**Growth, Environment
& Transport**

12 September 2024

Re: Application for an Order Granting Development Consent for Stonestreet Green Solar – Relevant Representation Submission

0m 50m 100m 150m 200m 250m

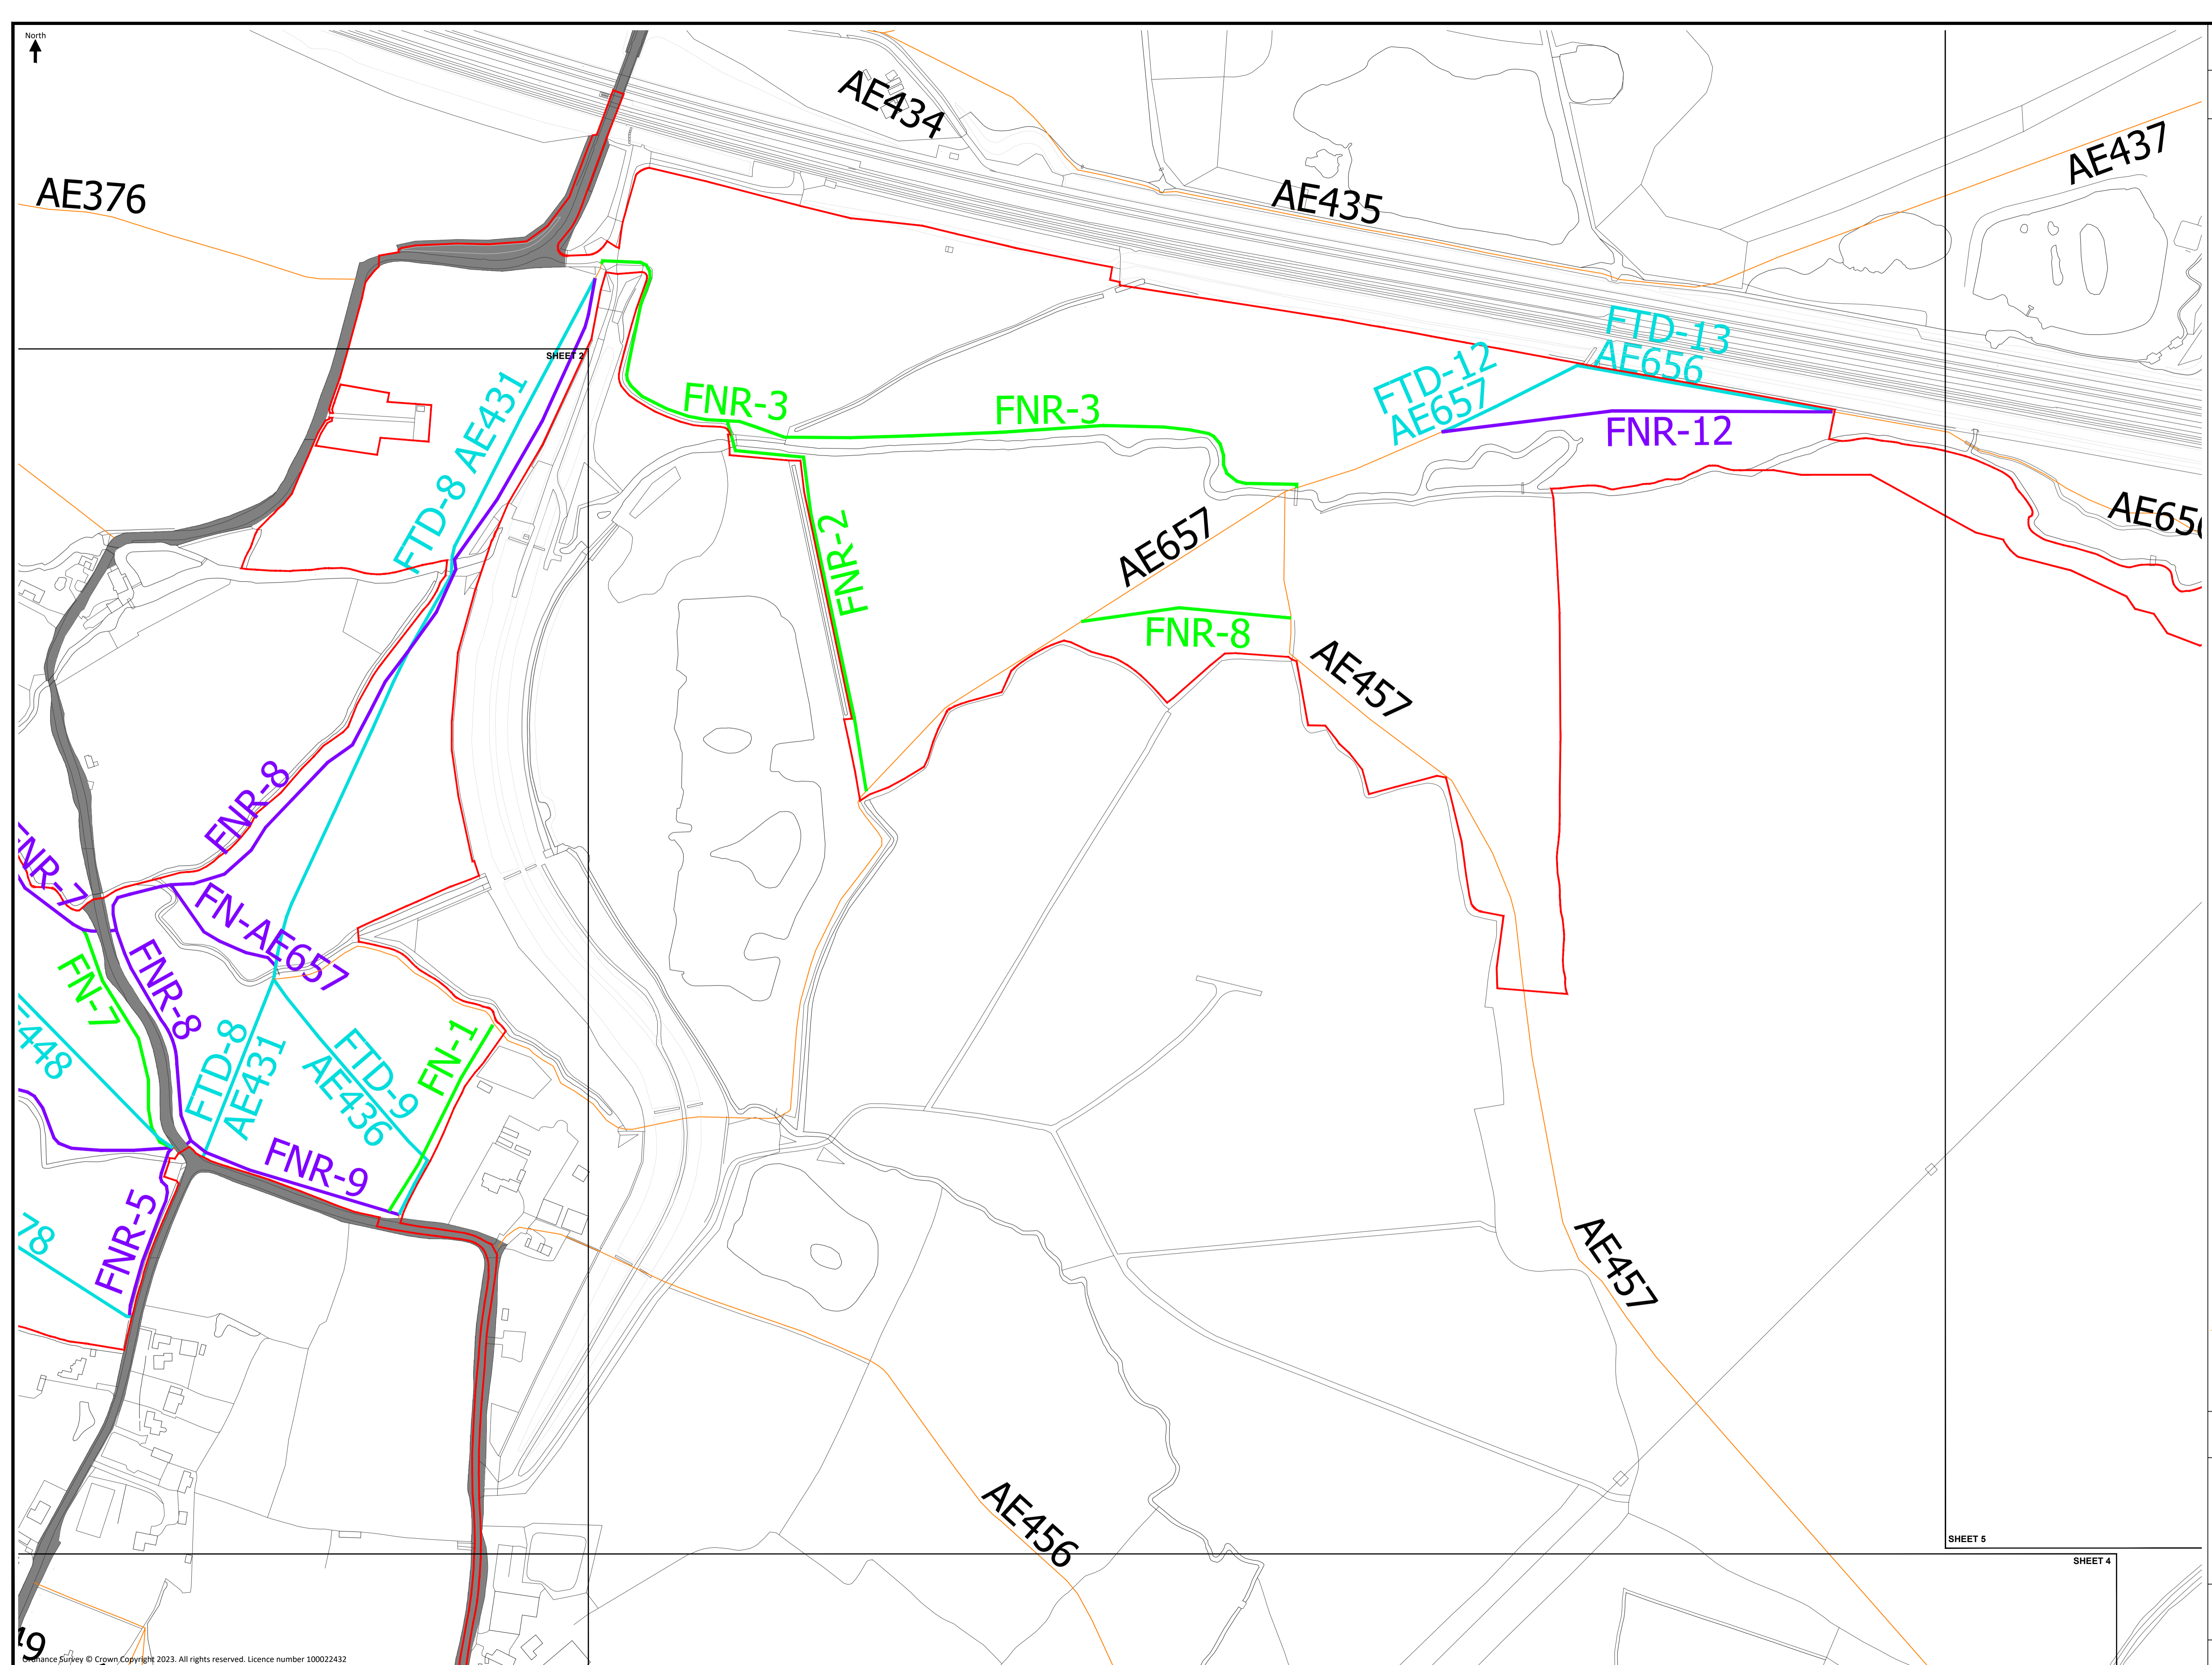
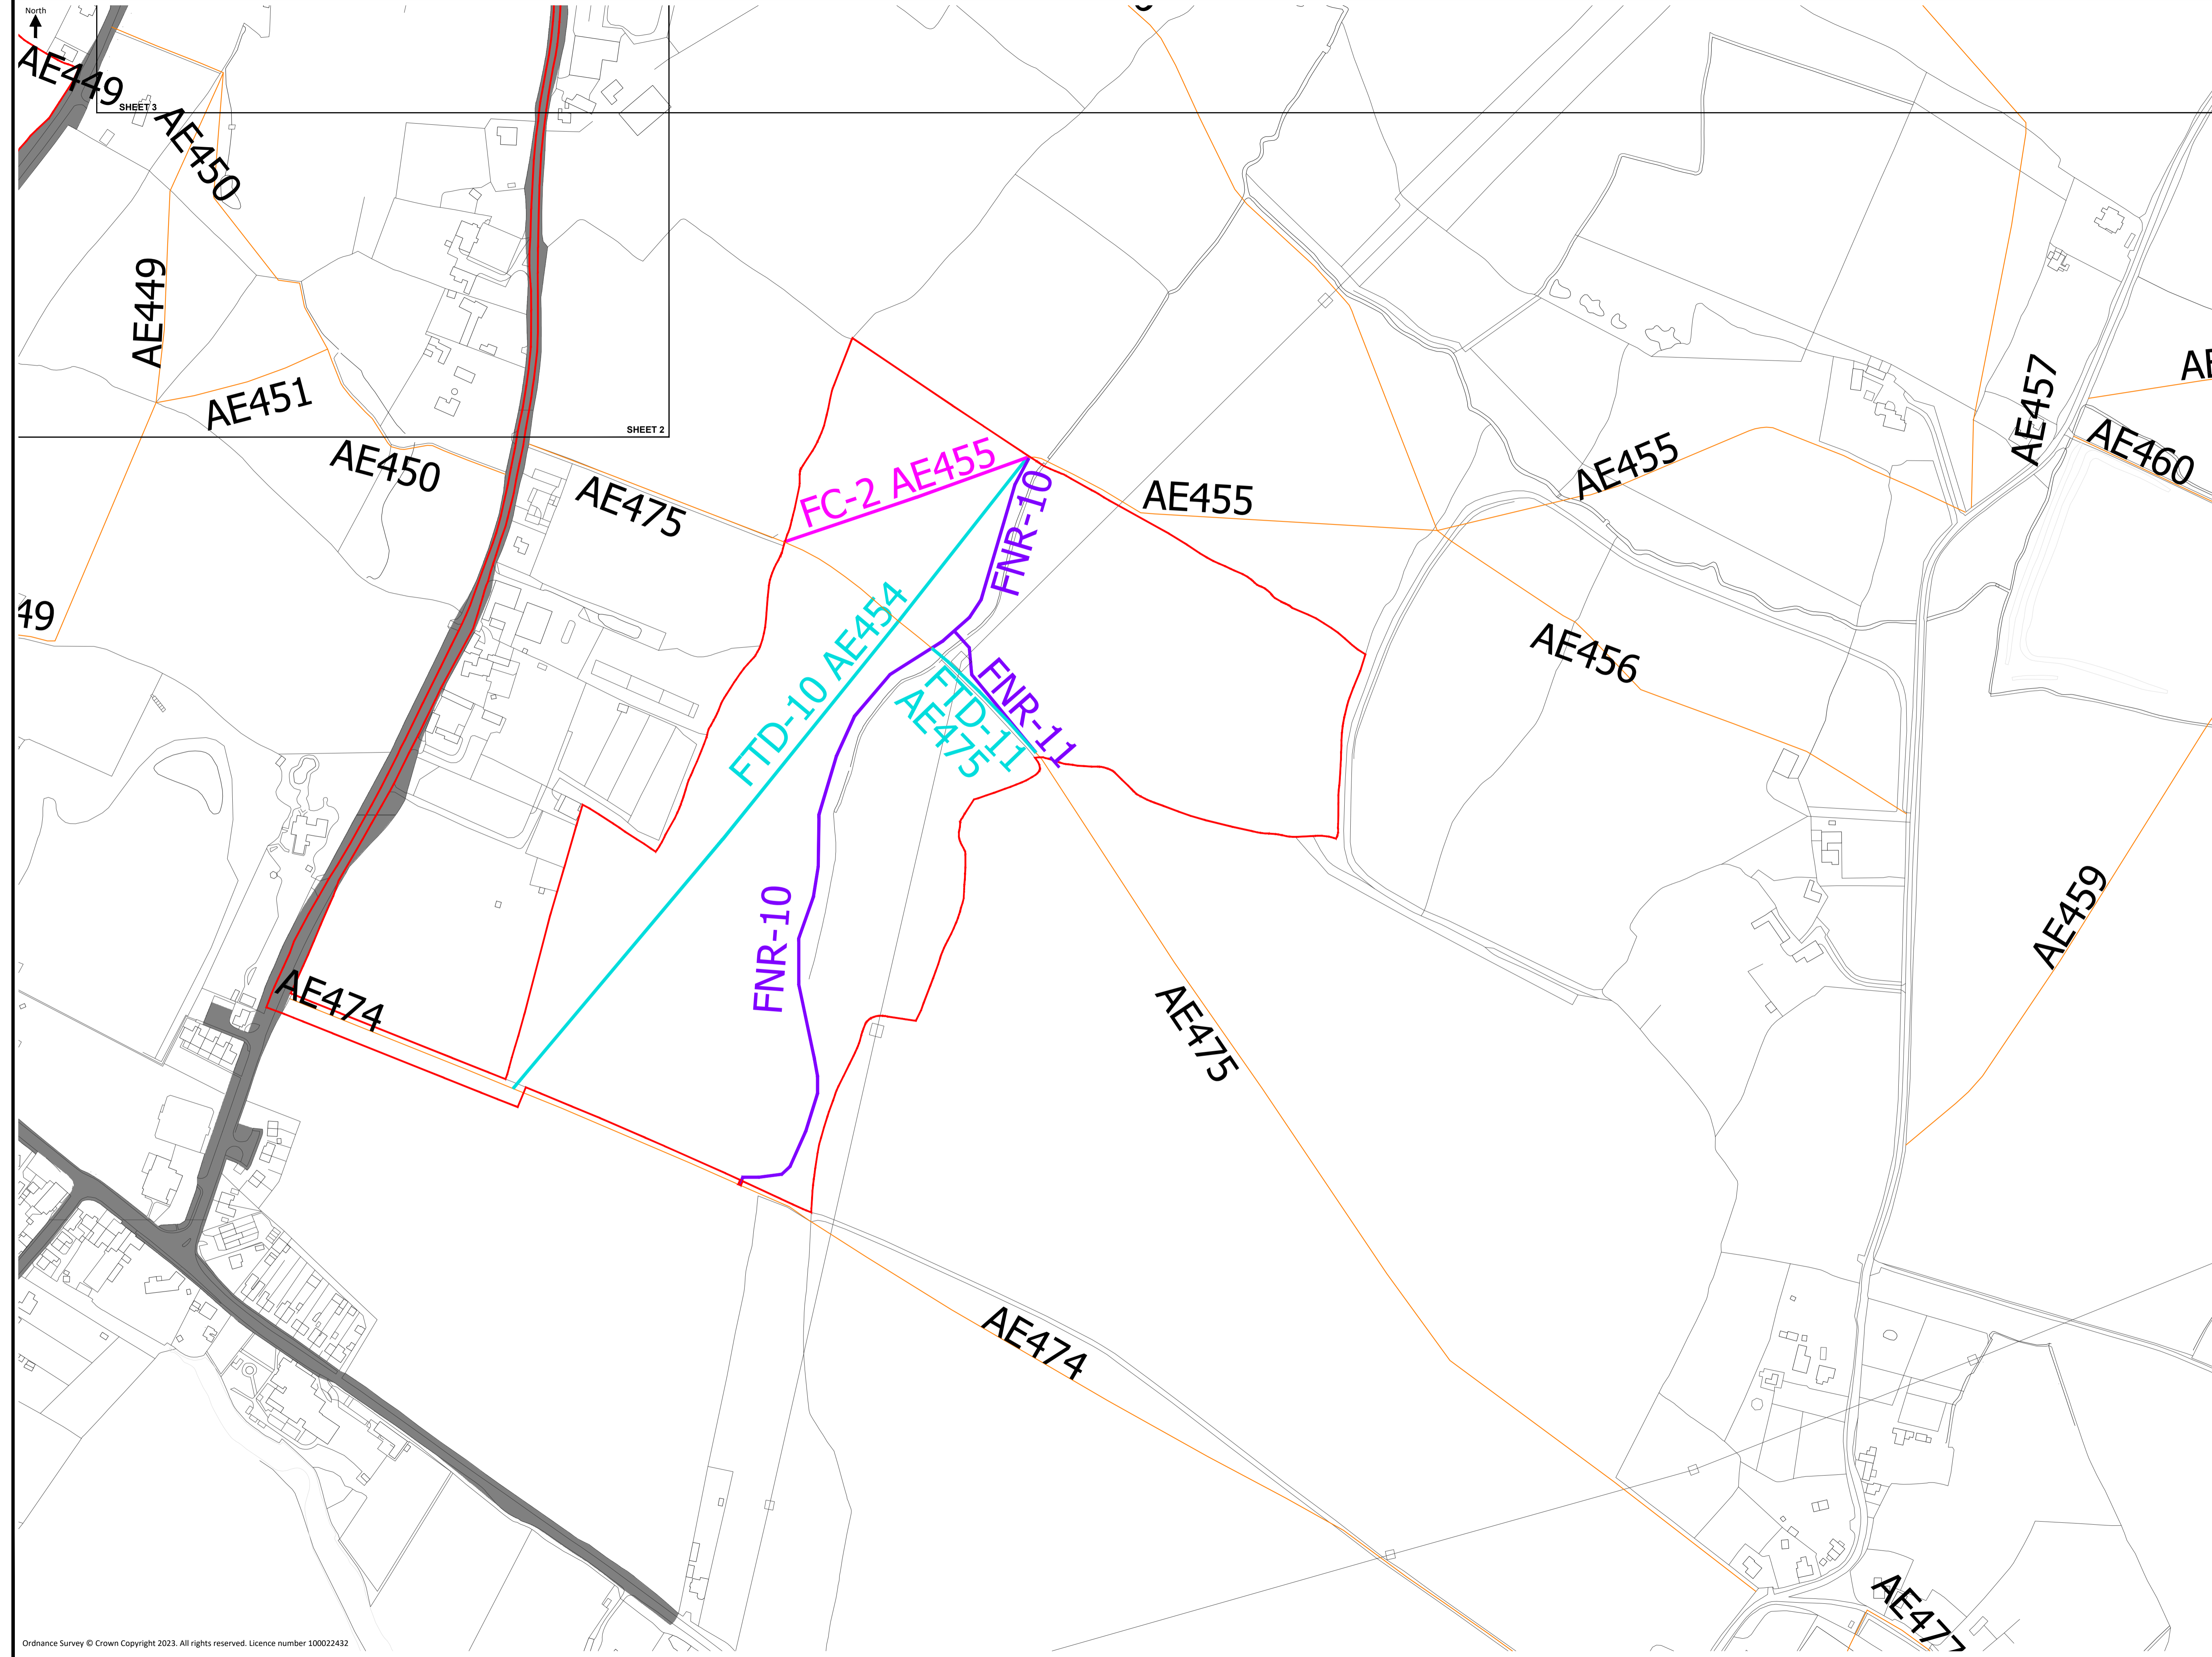
As part of the access strategy, to reach all of the plots to the south of Bank Road, the proposed routing as shown uses the existing access road to Bank Farm. Although the crossing of Bank Road itself can be undertaken via traffic management, the Bank Farm access road is already restricted in width and only wide enough for one-way working for vehicles. Visibility is not adequate from the southern end of the access road to the Bank Road junction to prevent conflicting movements. Any resulting reversing manoeuvres of large vehicles for both direct solar site traffic or other access users would not be welcomed. There are other business interests and access needs on Bank Farm and increased use of this access road with large vehicles with no improvements would not be sensible. Localised widening to the access road to allow for overtaking space, taking account of forward visibility, should be implemented. Revision/clarification on this issue is required by the County Council ahead of the commencement of the Examination.
